From: Joanne Lewis
Sent: 14 June 2019 13:59
To: Planning.Responses
Subject: FW: Y/48/19/DOC - Cinders Lane Nursery and works to the rear Cinders Lane, Yapton, BN18 0JJ
Importance: High

Further to my email sent earlier today, please refer to the email below from my client and the attached Site Wide Elements Plan ref. 19.14.102C, which you should substitute for the version currently lodged.

SITE WIDE ELEMENTS PLAN
DEVELOPMENT AT:
CINDERS LANE
YAPTON
BN18 0JJ
FOR
CRAYFERN HOMES LIMITED
Scale : 1:500 @ A1 Date : Feb 2019
Drawing No : 19.14.102 C

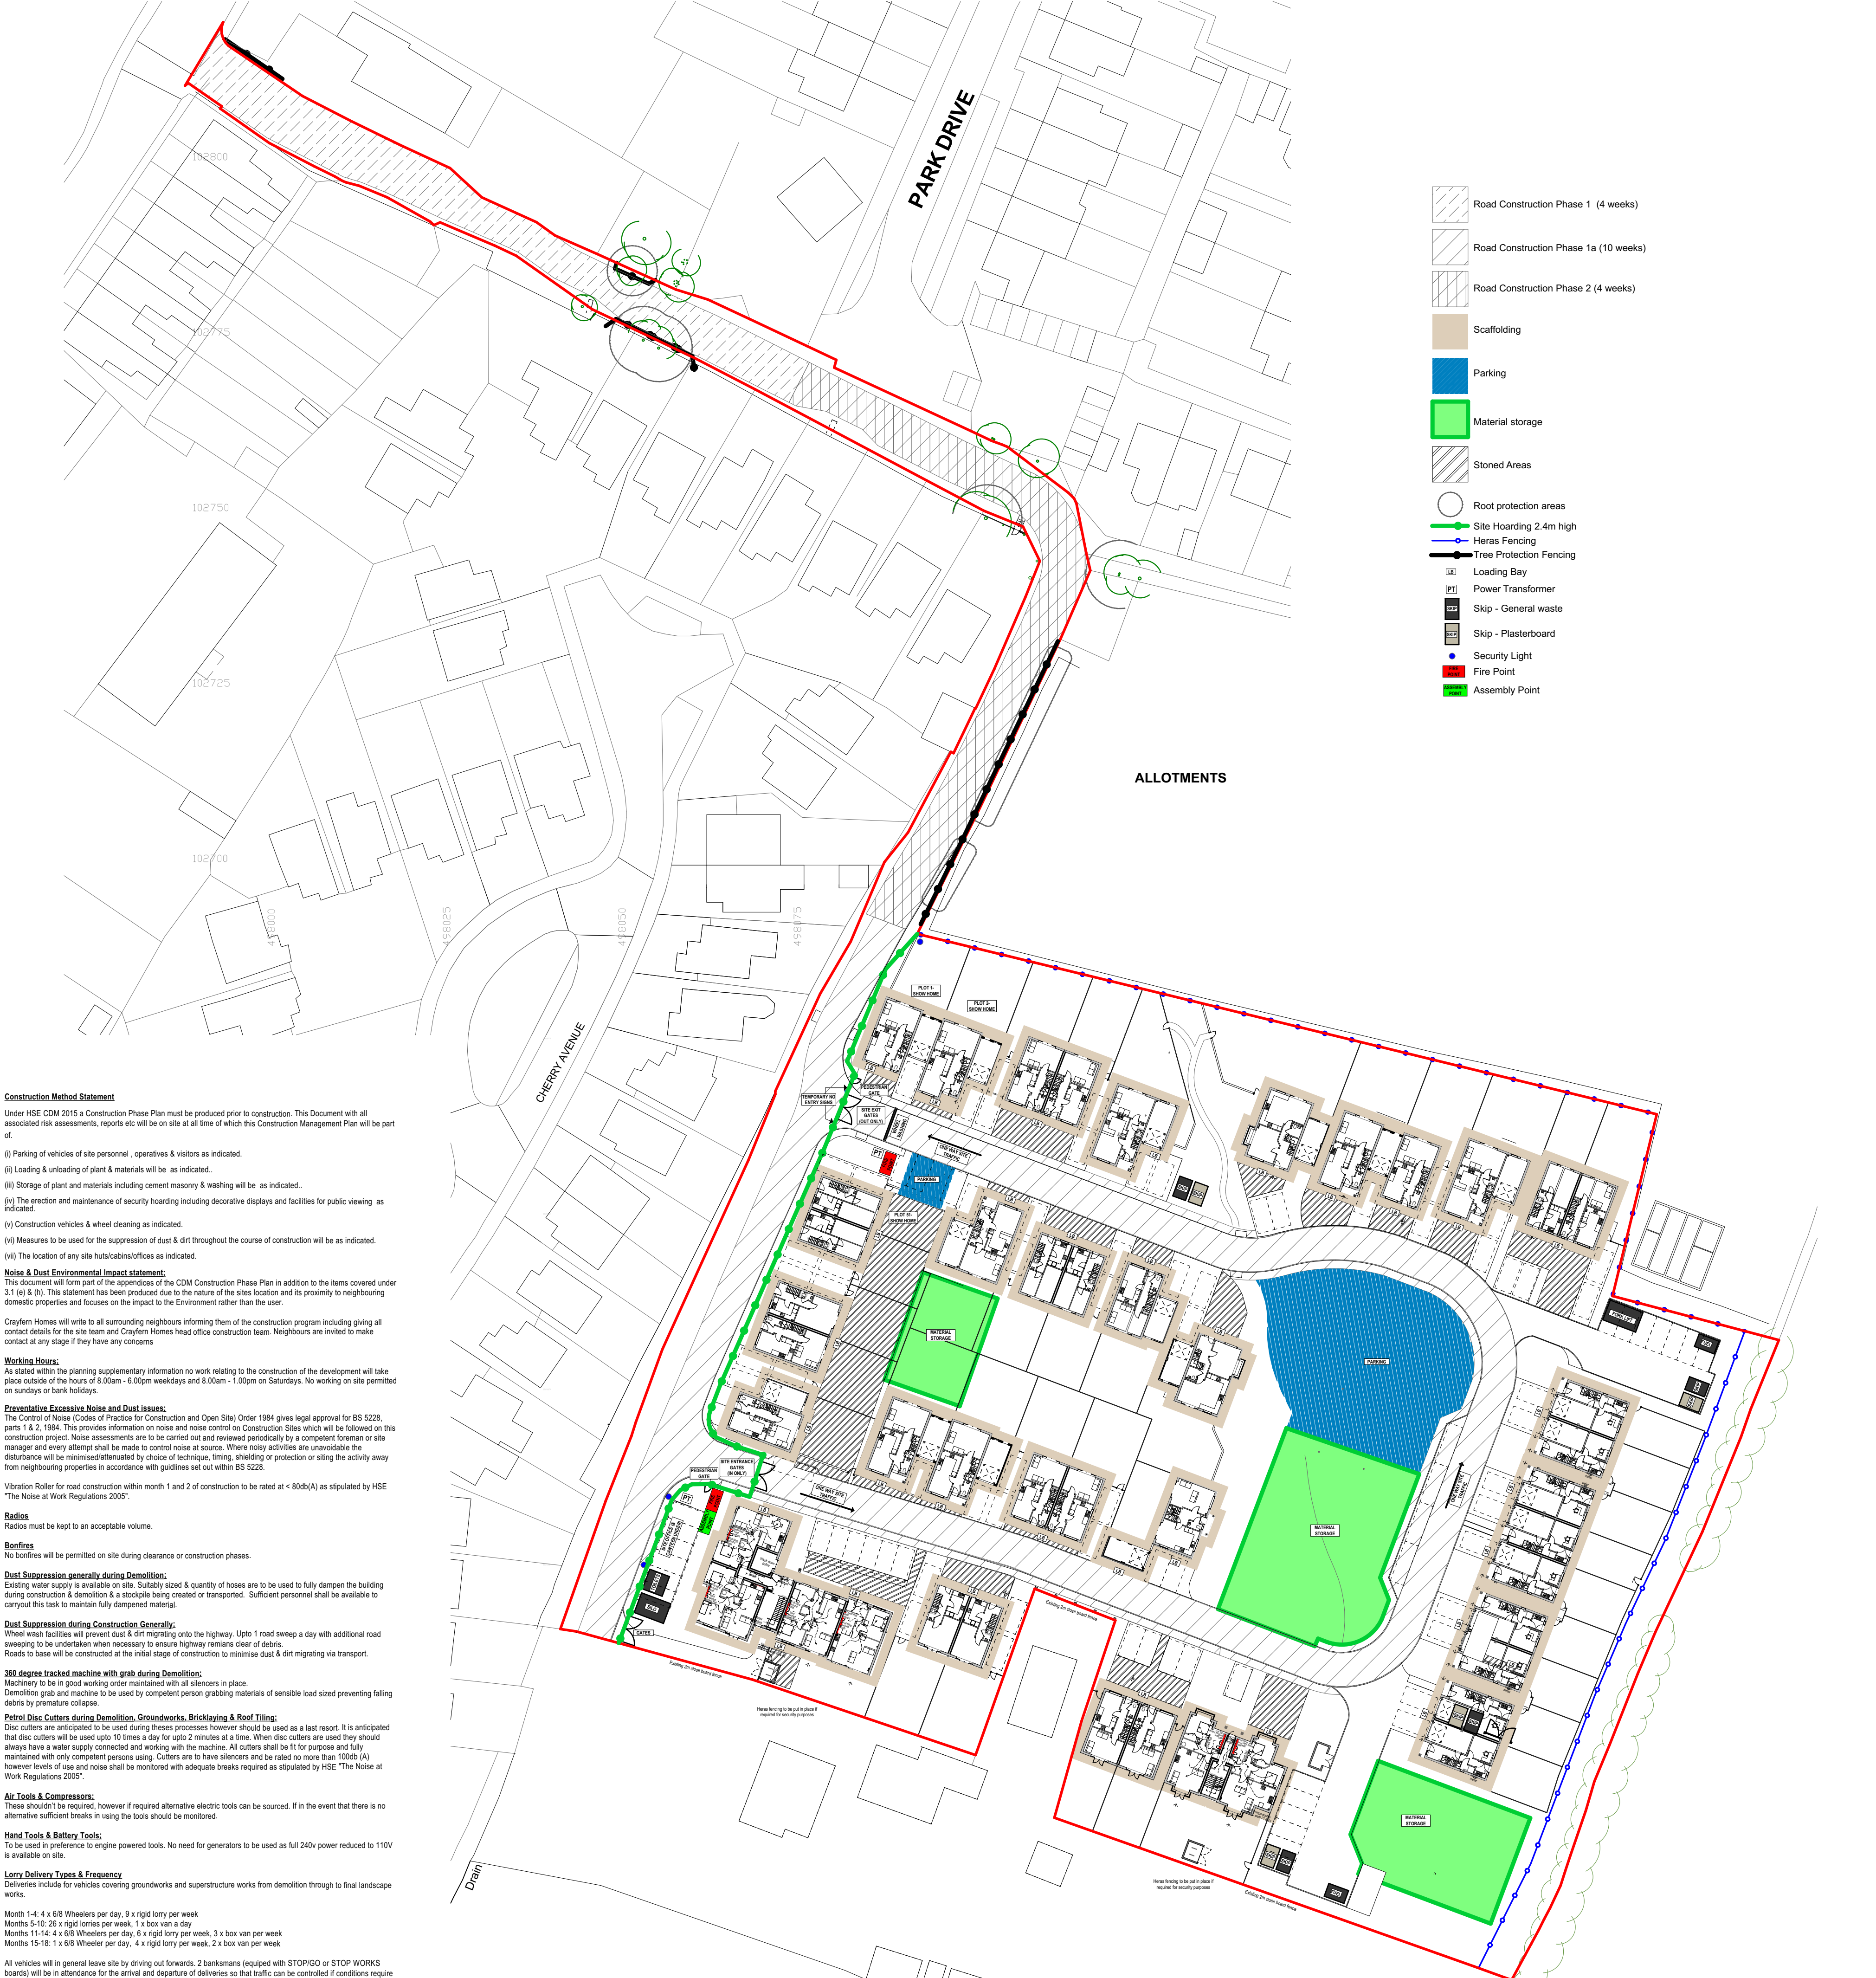
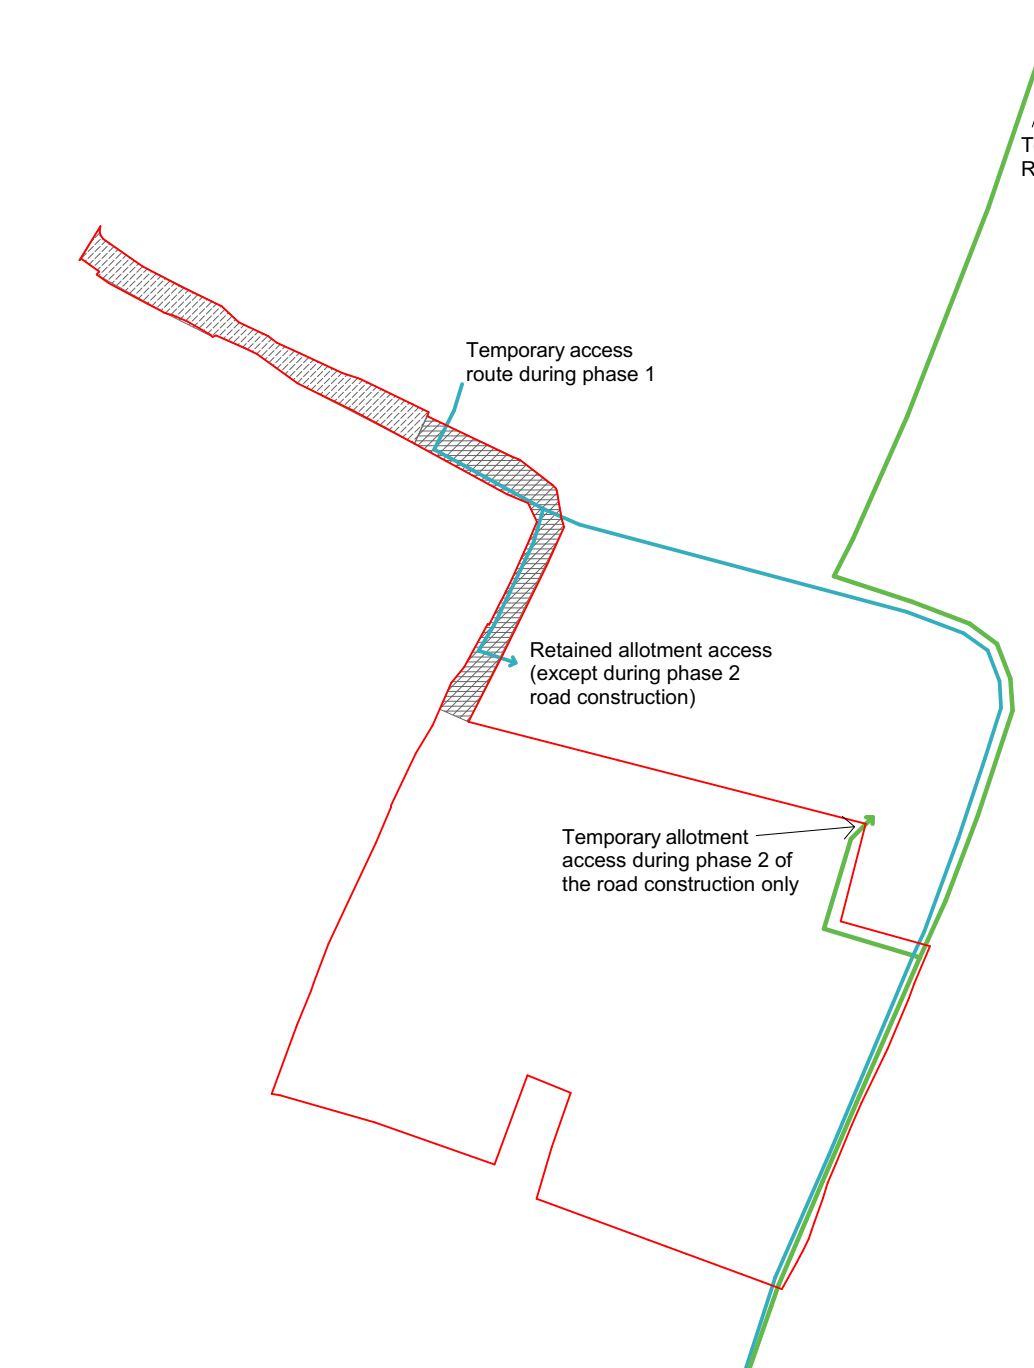
A slight oversight on our part but we shouldn't have shown heras fencing to the south boundary where it adjoins residential property. There is an existing 2m close board fence to this boundary and we would only put up heras fencing if required for security purposes. This has now been noted on the drawing and the heras fencing removed.

Also, the drawing now shows the site to the south as per the existing layout and does not show anything indicating the potential residential layout following their outline planning permission.

I'm sure my client will be able to revise the Site Wide Elements Plan ref. 19.14.102 in the manner requested in the attached email. I'll send you a revised version of the plan as soon as possible.

Taking into account the revised site wide elements plan I am happy for the discharge of condition 9.

Please find attached an amended site wide elements plan following comments from environmental health.
